Rezoning Transportation Analysis

Petition Number: 2021-081

Date	Description
08-02-21	First Review (LH)

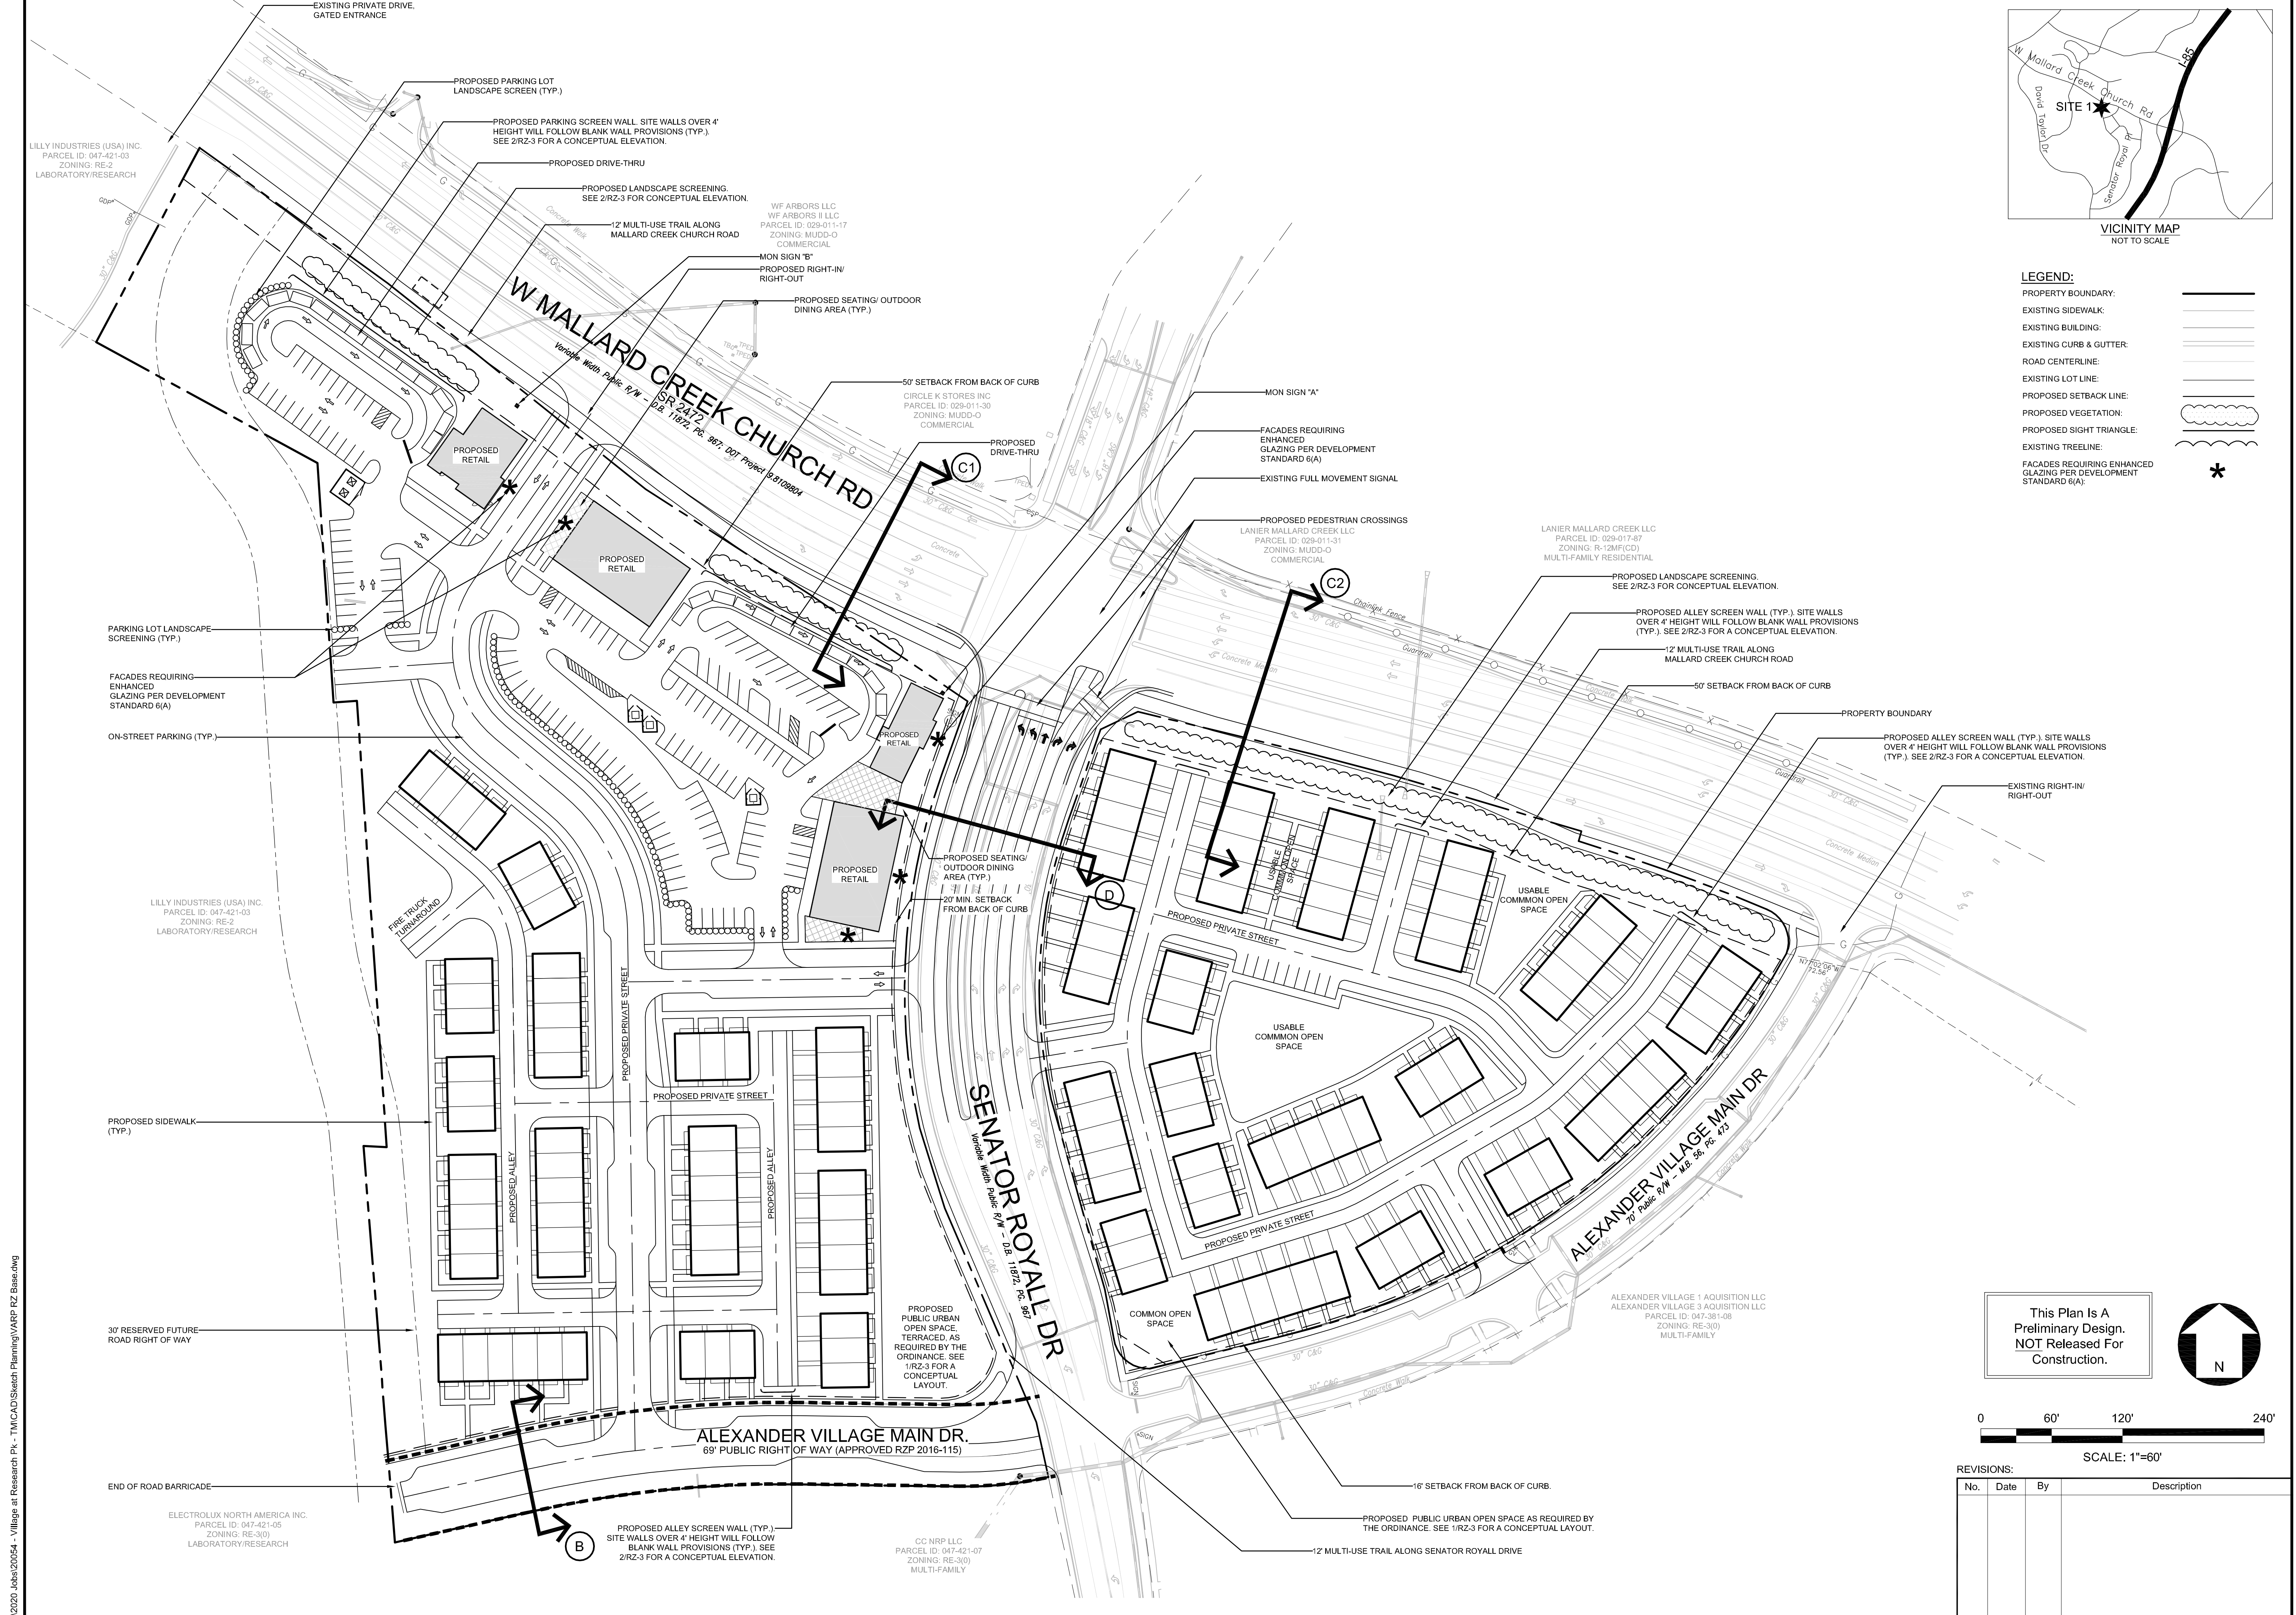
- Curbline:** The proposed zoning district has a setback measured from back of the existing or proposed future curbline.
- Traffic Study:**
~~Since traffic impacts have not changed for this site the previous rezoning petition, a Traffic Impact Study (TIS) is not necessary for the complete review of this petition.~~
- Per NCDOT coordination and review of this petition, the site plan and conditional note(s) revisions are needed to show the right turn lane from Mallard Creek Church Road into the site (see below):

PROPOSED SENATOR ROYALL DR (SECTION 'D')
SCALE: 1"=10'

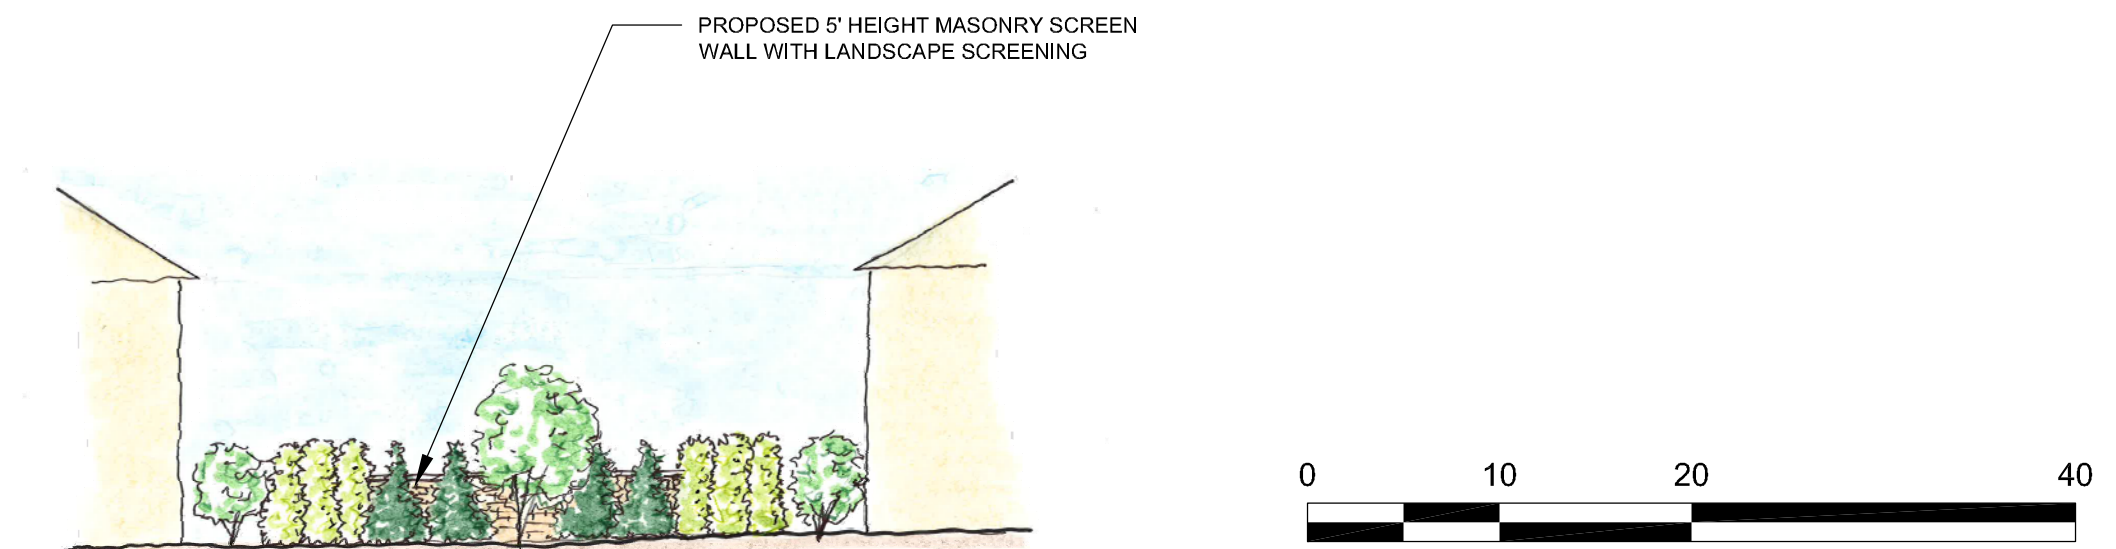
- Site plan and conditional note(s) revisions are needed to show the 12' MUP on both sides of the proposed Senator Royall Drive (Section D) – see below:
